2023/0502

343 Higham Common Road, Higham, Barnsley, S75 1PG

Single storey rear extension

Drawing Title: PLAN AND ELEVATIONS AS PROPOSED

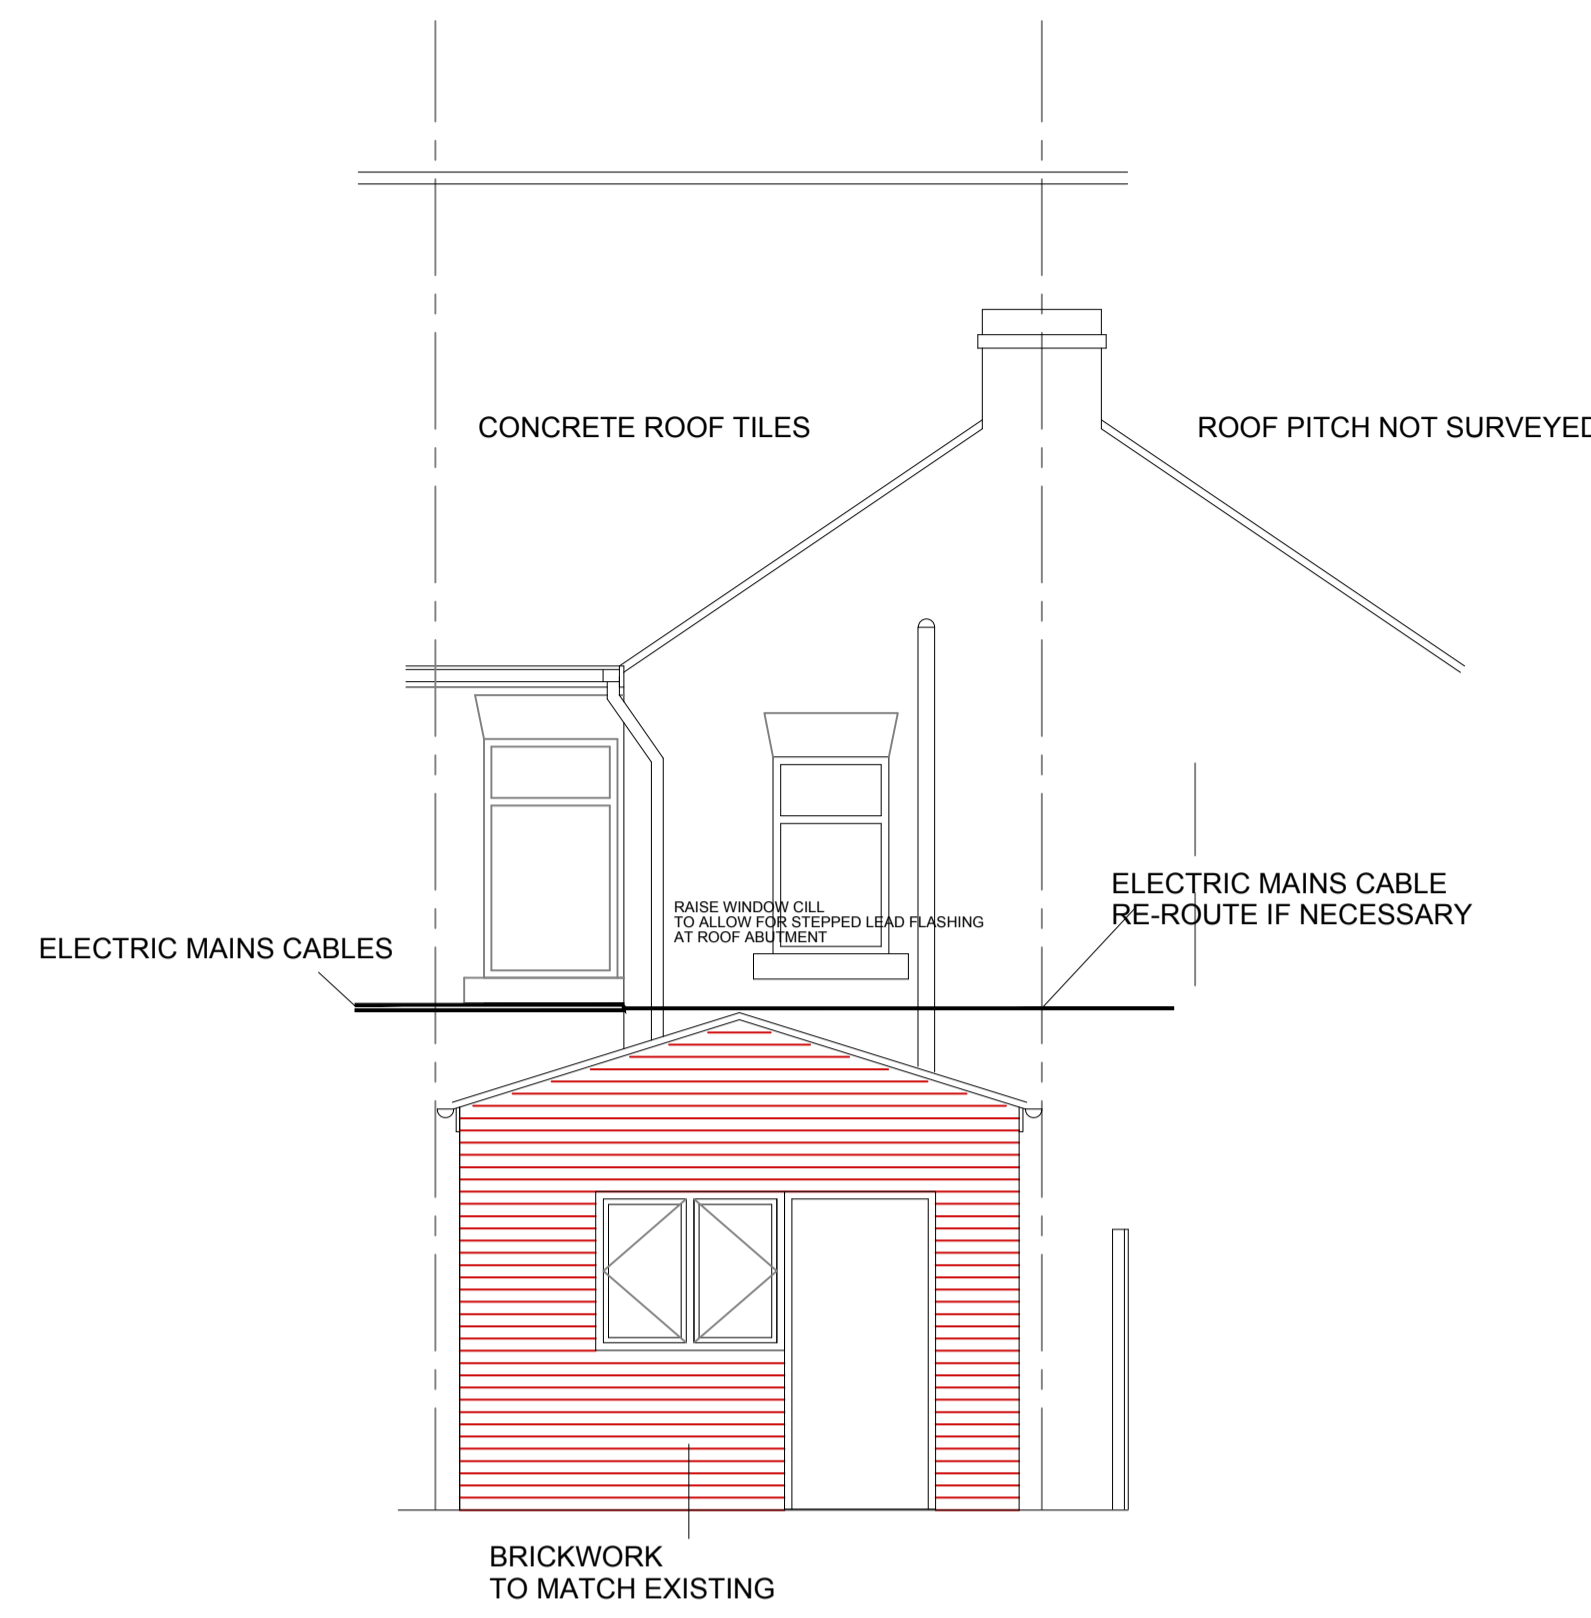
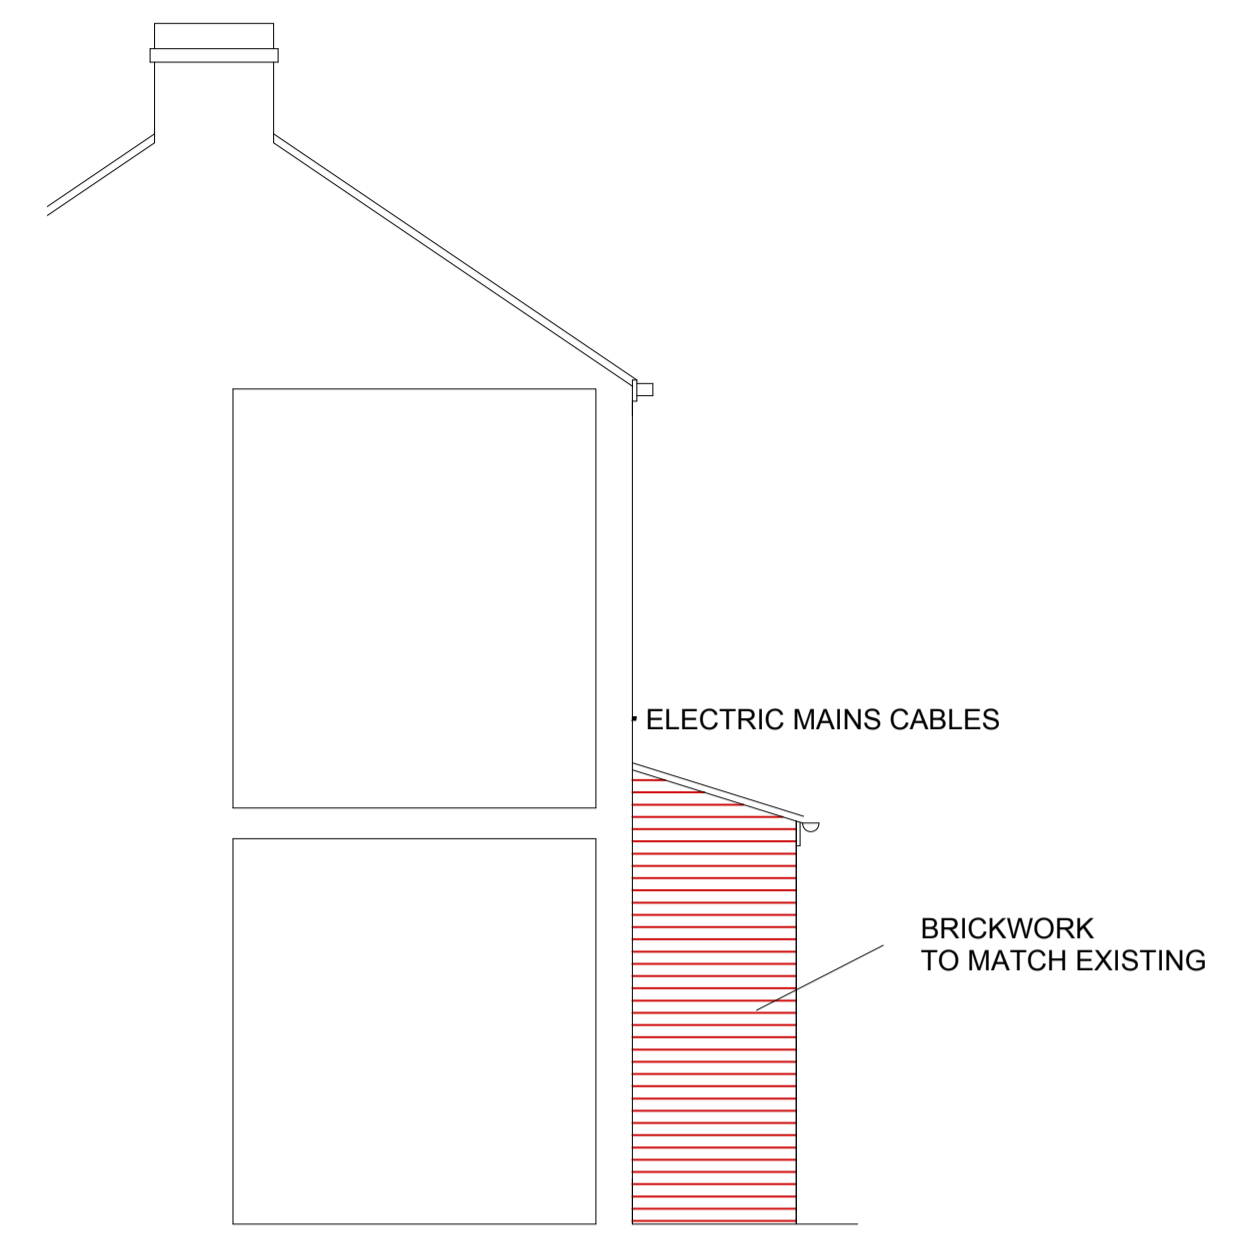
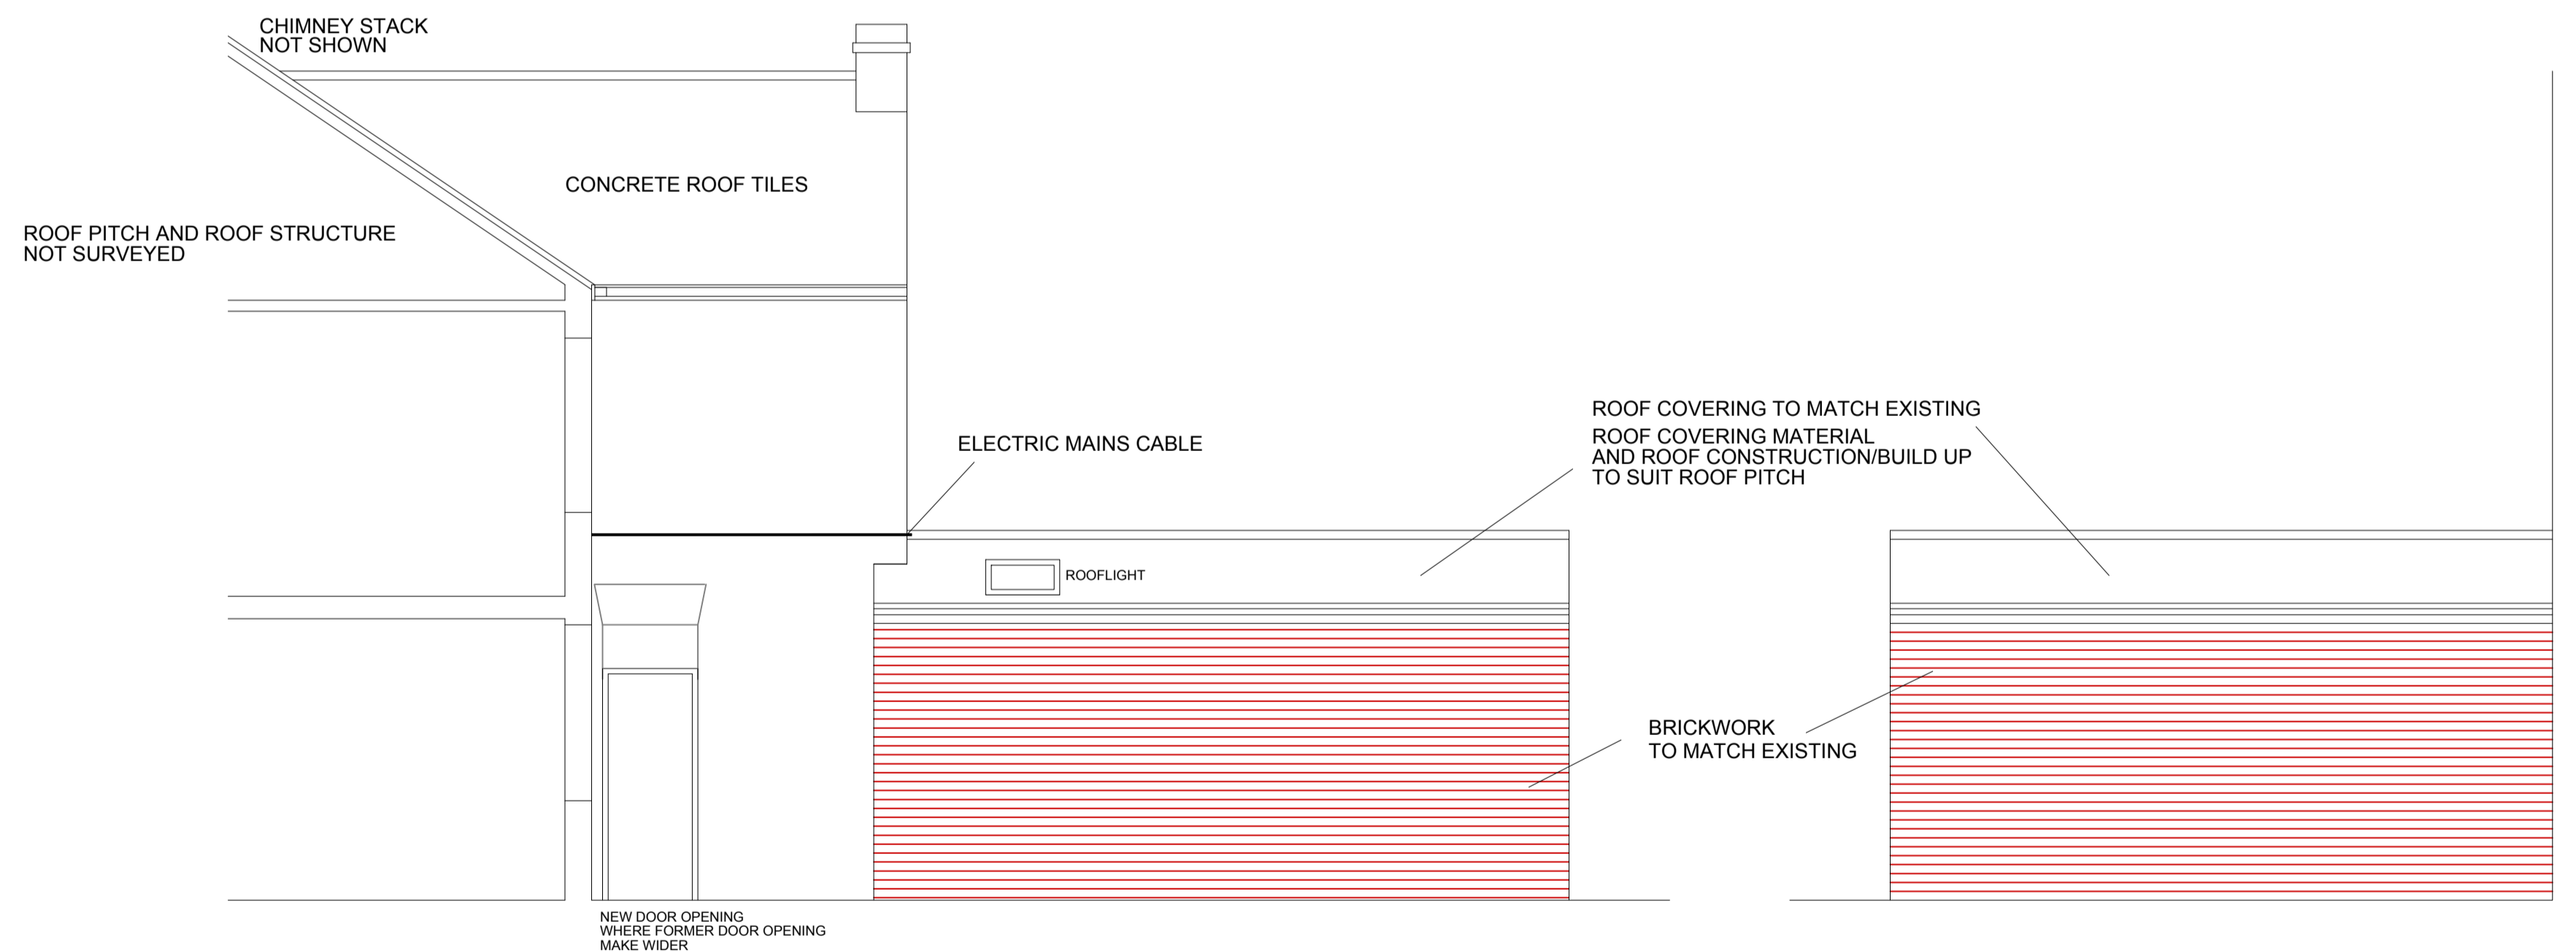
Paragraph 8.3 of the SPD states that *'single storey extensions to the rear of terraced houses should not exceed 3.5 metres in projection, and where they exceed 3 metres the eaves height should not exceed 2.5 metres.'* In this instance, the proposed extension would be to the rear of a terraced property and have a projection of approximately 6.3 metres with an eaves height of approximately 2.7 metres, therefore, not meeting the guidance of the SPD.

Additionally, the proposed extension would be positioned South-East of adjacent neighbouring property 341 Higham Common Road; as such, greater impacts regarding overshadowing should be expected due to the natural movement of the sun path. Whilst it is acknowledged that existing boundary treatments comprising of high timber fencing and neighbouring properties to the North of 341 Higham Common Road likely contribute to existing levels of impact, the scale of the proposed extension and its proximity to the boundary fence would create an unacceptable tunnelling affect that would increase levels of overshadowing to an unreasonable degree, particularly affecting the rear garden and ground floor rear-facing window of 341 Higham Common Road. Paragraph 7.7 of the SPD states that *'the Council will seek to protect principal habitable room windows on the front and rear elevations of the adjacent property.'*

Furthermore, whilst outlook from the ground floor rear-facing window of 341 Higham Common Road is likely to be impeded by existing timber fencing forming the rear boundary treatments, it is considered that the scale of the proposed extension and its proximity to the boundary line would exacerbate existing impacts, further reducing outlook.

Though the proposals are not considered to result in increased levels of overlooking and loss of privacy, the proposed extension would be an overbearing addition to the applicant dwelling that would adversely affect the amenity of neighbouring properties, including increased overshadowing, and further reduced outlook.

In conclusion, the specific concerns regarding these proposals relate to the scale of the development and the likely impacts to residential amenity, including overshadowing and reduced outlook due to the creation of an unacceptable tunnelling affect, and the minimal detail provided regarding parking arrangements to be able to fully understand and assess the impacts of the proposals on highway safety.

Specific concerns were raised regarding loss of privacy to neighbouring properties South of the site due to the proposed replacement of a ground floor window with a door opening on the side elevation of the existing rear projection of the applicant dwelling. It was stated that the passing of the occupant and visitors via this new opening would lead to an erosion of privacy. It is acknowledged that the proximity of the proposed door opening to neighbouring property 345 Higham Common Road would have some impact regarding loss of privacy, however, it would replace a window in a similar location, and be in the context of large open space to the rear of this row of terraced properties (341 – 355 Higham Common Road) that is likely to contribute to existing levels of impact. Additionally, the replacement of a window with a door would not require planning permission in this instance, resulting in the same impacts. As such, it is not considered that the proposals would increase impacts
